From: Graham Evans
Sent: 12 January 2012 10:58
To: Planningecons
Subject: FW: Planning Consultation on: A/164/11/

APPLICATION NO: A/164/11/

Registered: 02-DEC-11
Site Address: The Lamb Inn The Square Angmering BN16 4EQ

Description of Works: Replace 2 windows, block up 2 windows, replace fire escape & new kitchen- extract

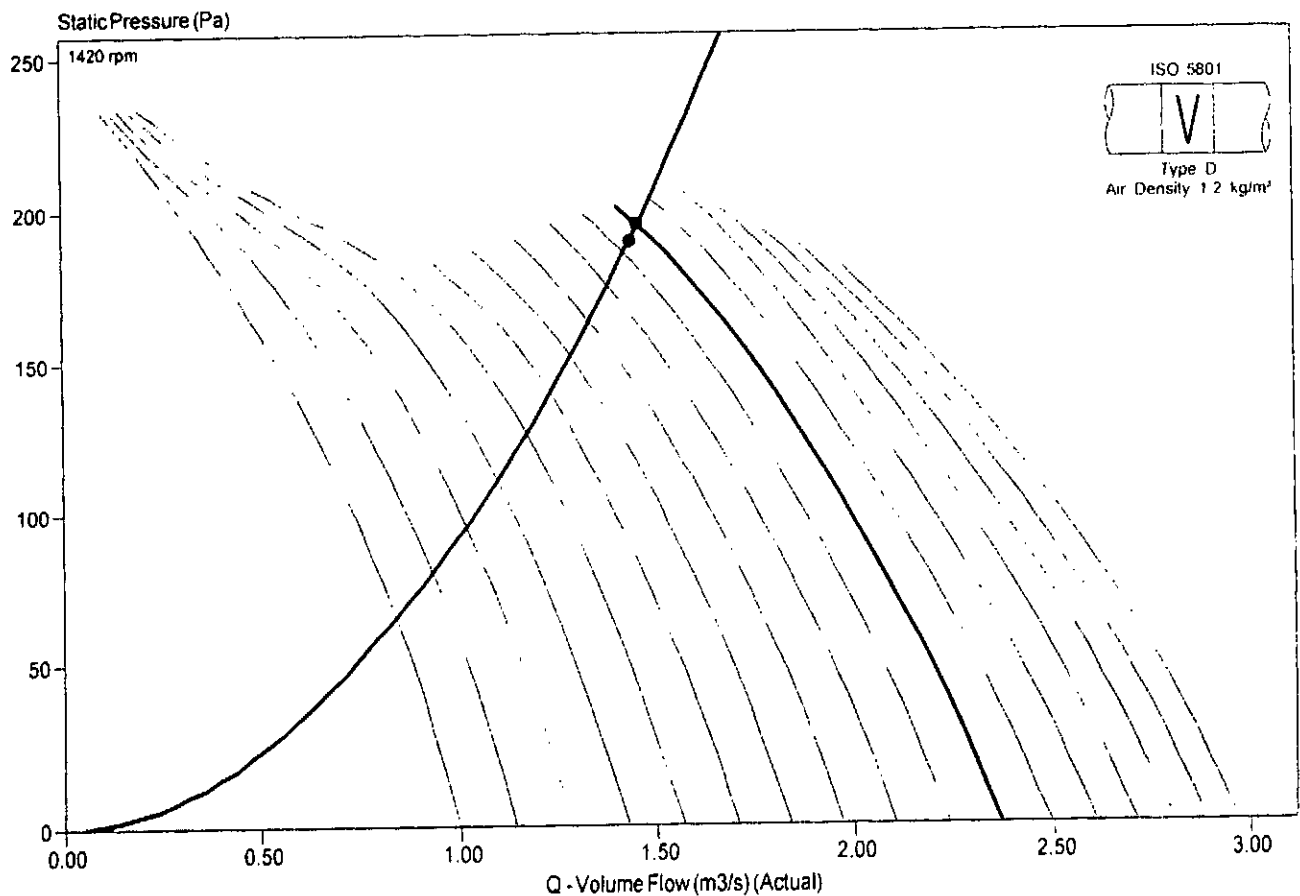
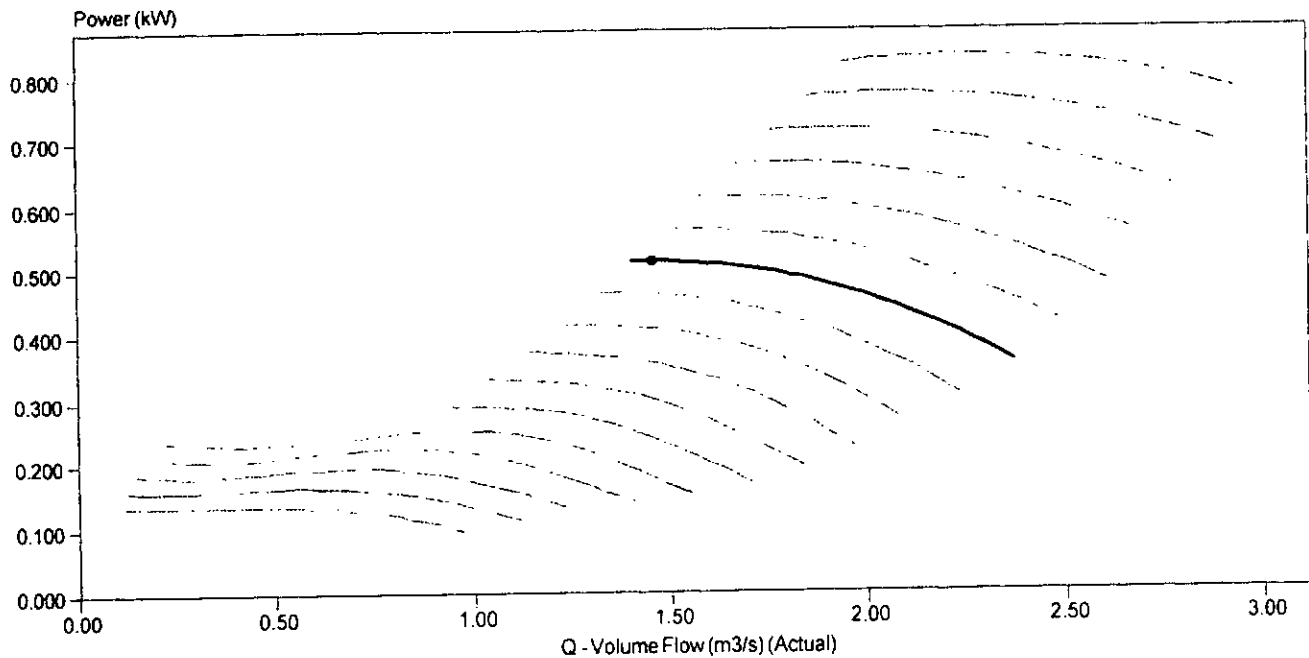
I concur with the views of the EH Food Team below. There is no information in respect of noise produced by the kitchen extract system (note 10 of attached guidance).

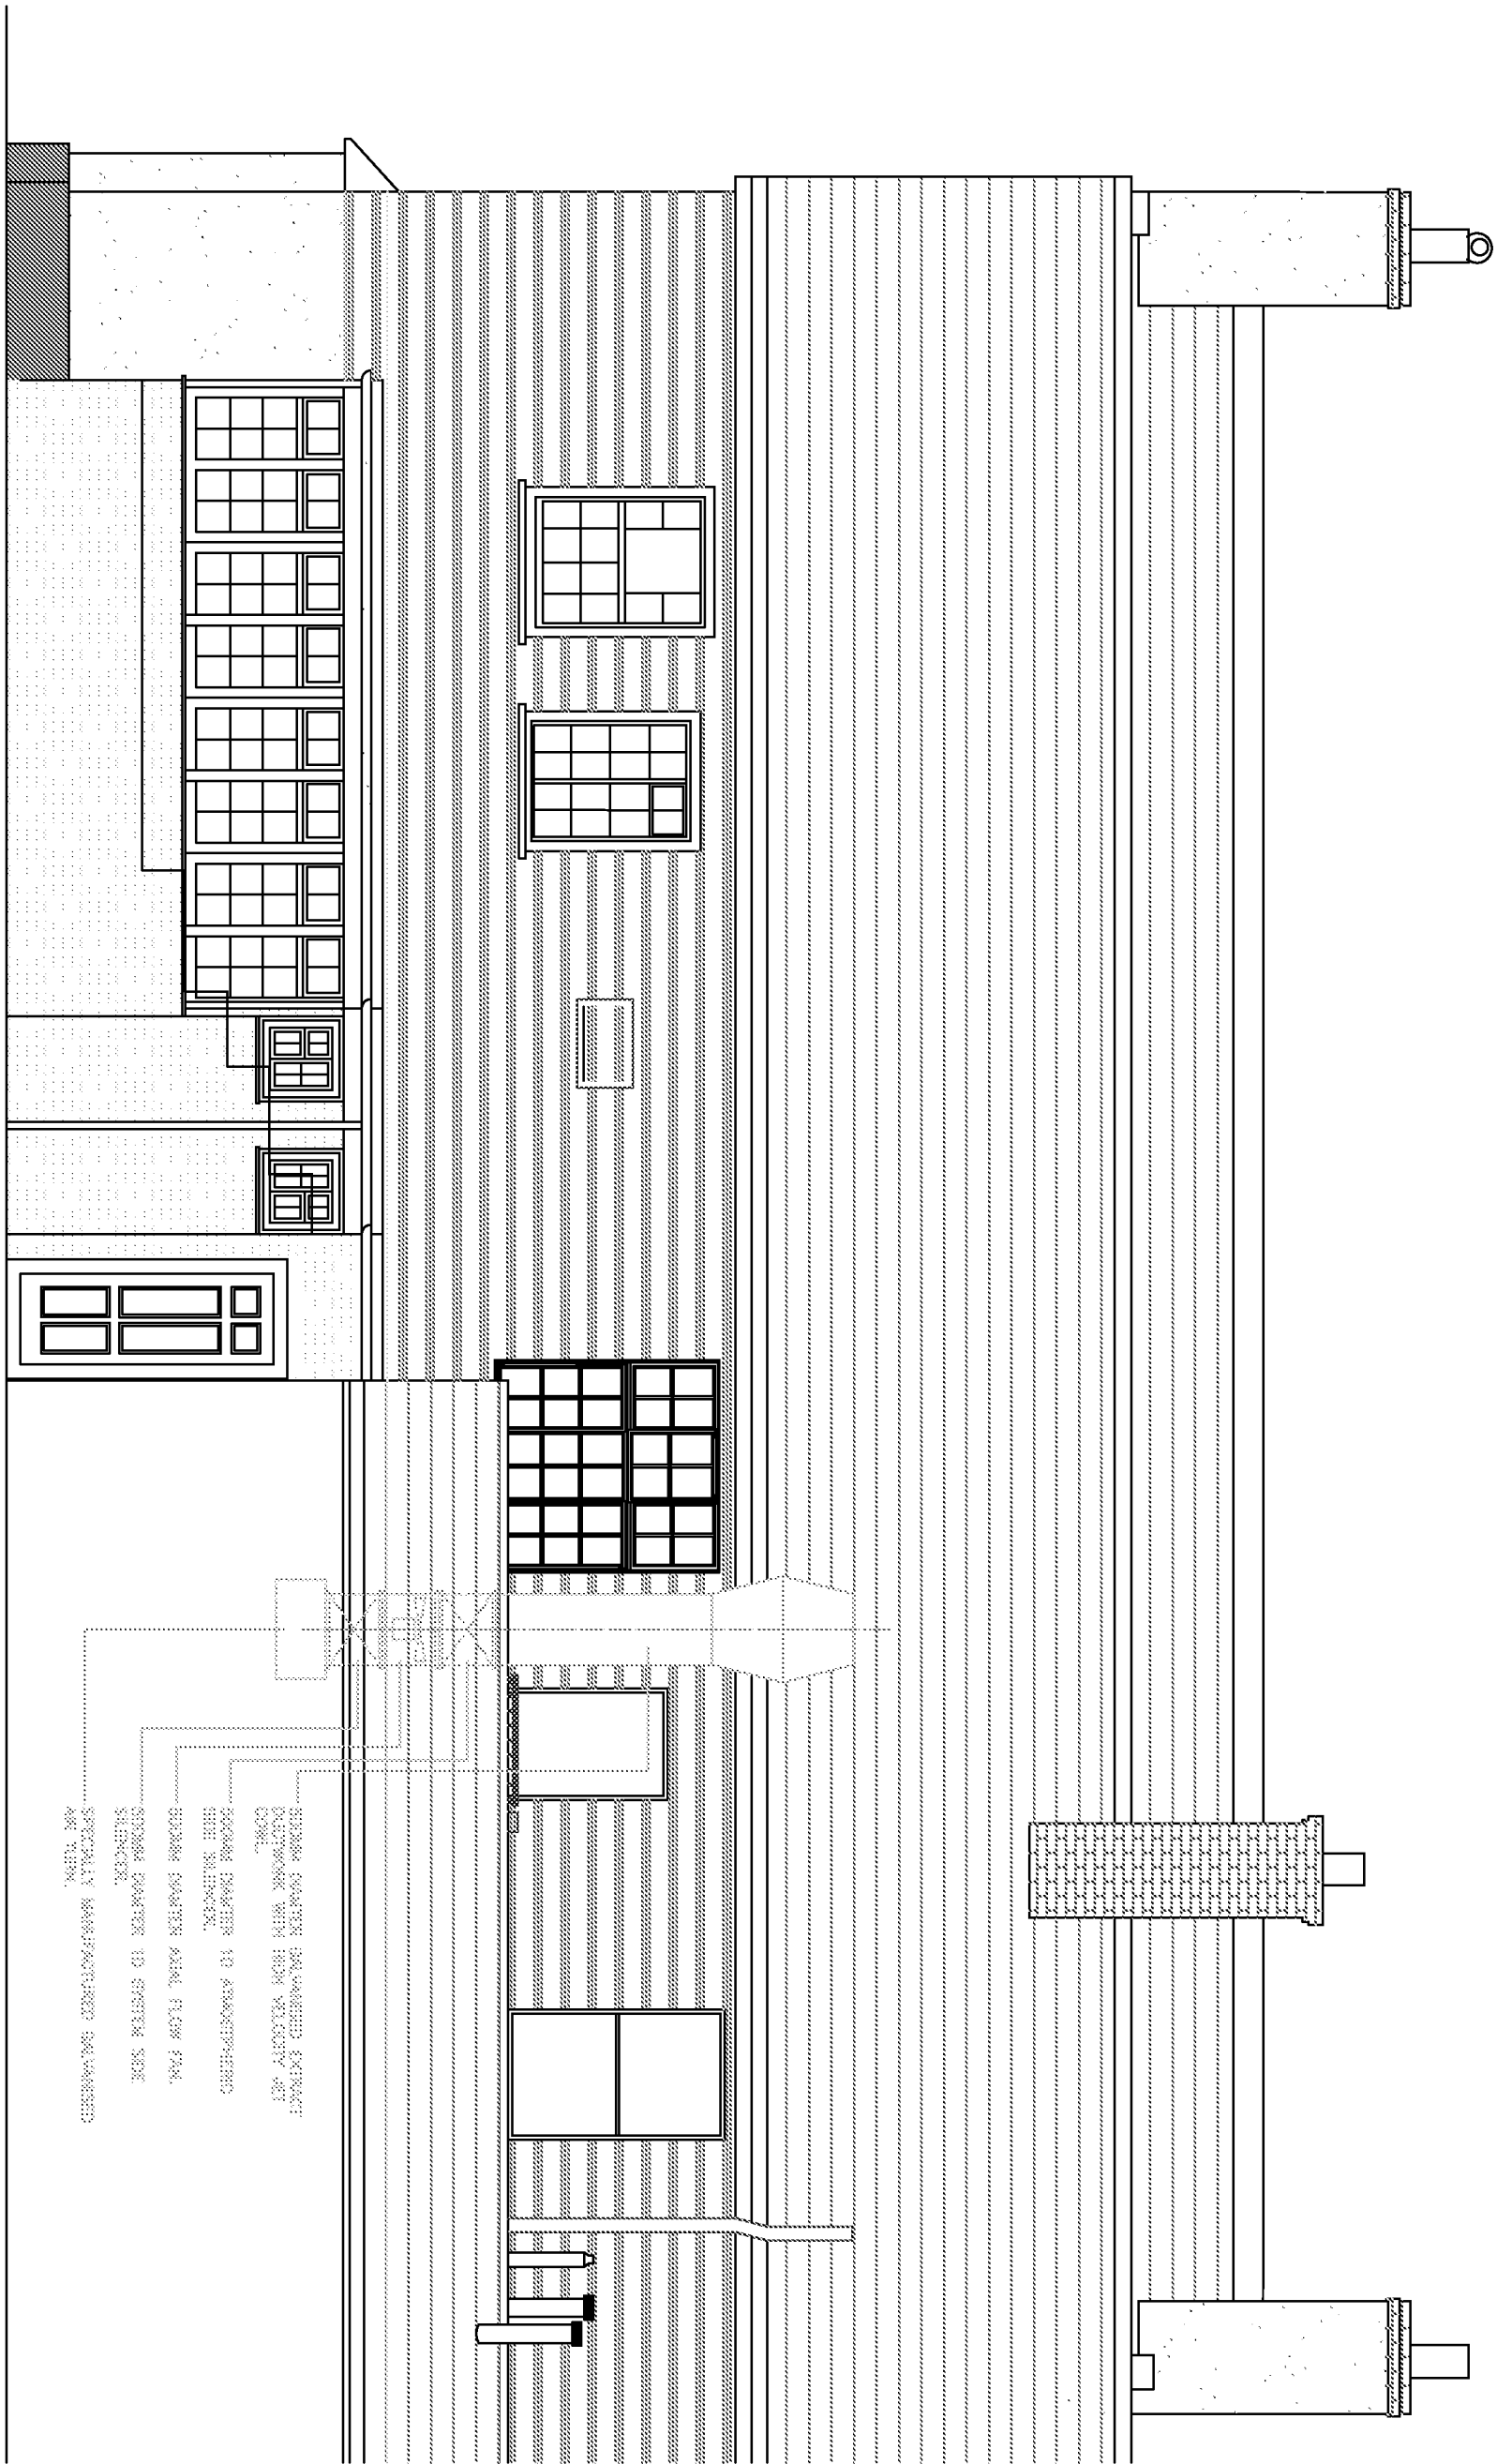
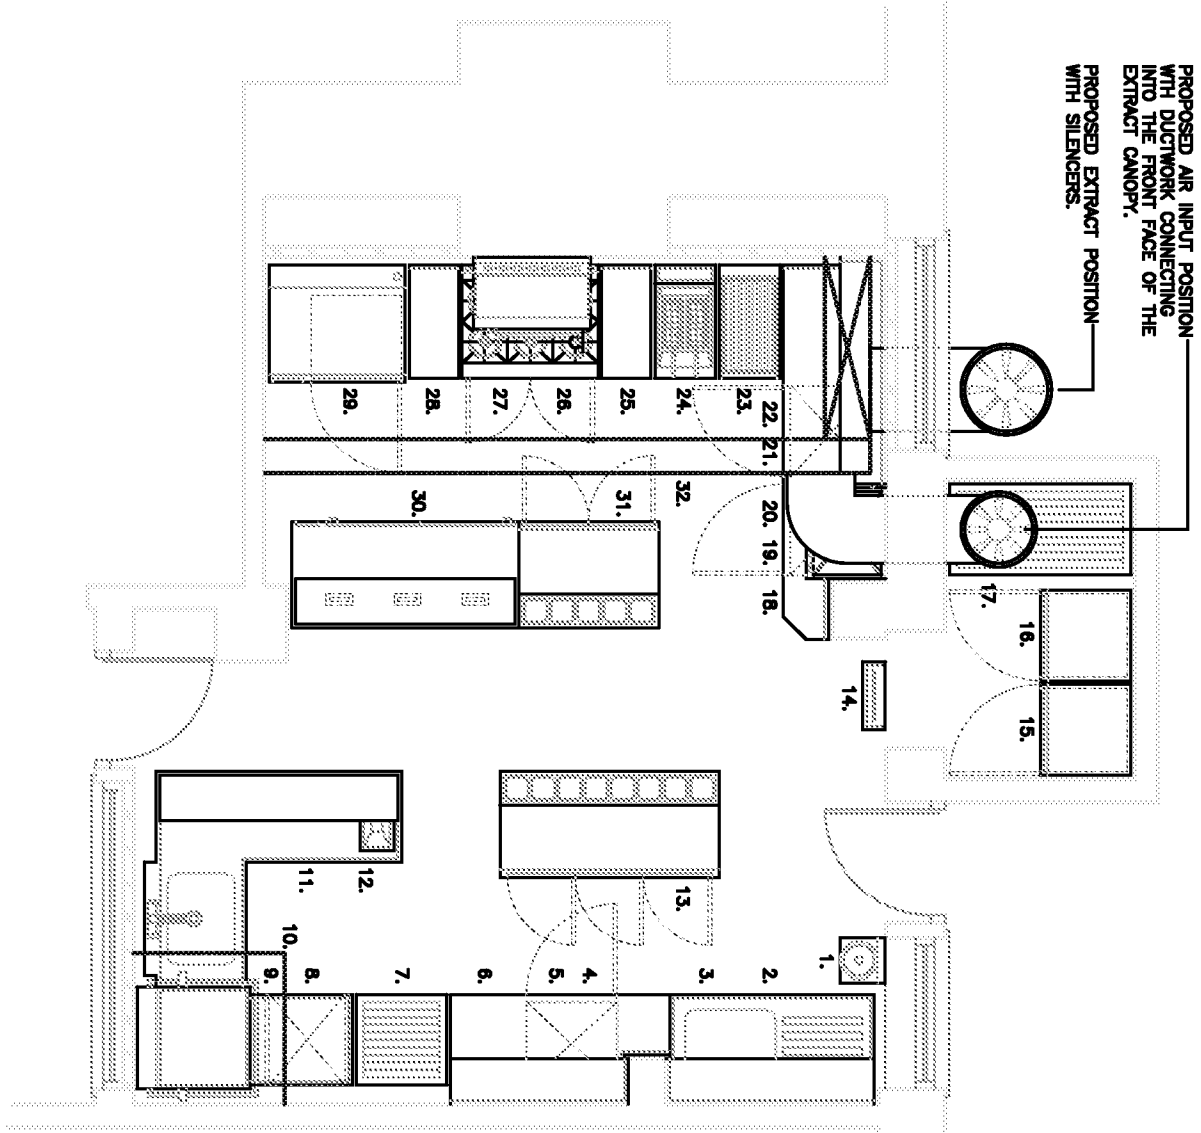
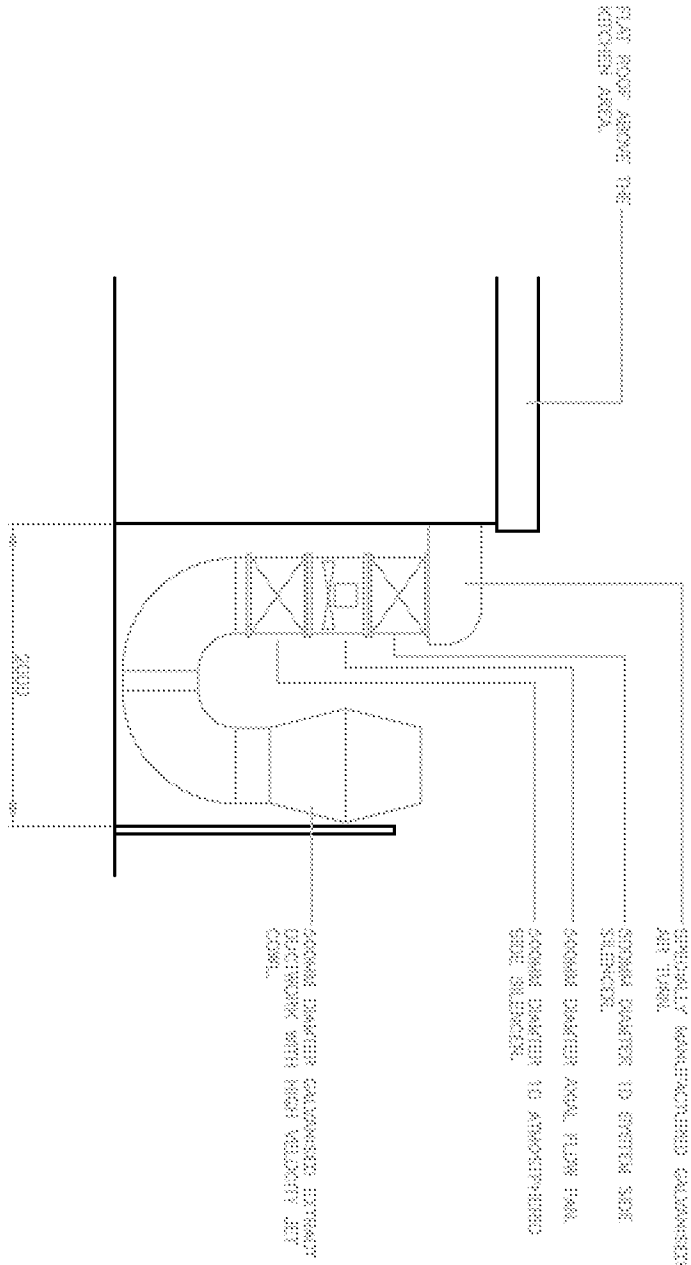
With regard to the provision of a new kitchen extract system at the Lamb Inn, Angmering I note that the applicant has not supplied any information regarding odour control. There are residential properties adjacent to the premises and in order to prevent a nuisance from cooking odours adequate extract ventilation and odour control equipment needs to be installed at the premises. Information should be submitted in line with the attached guidance.
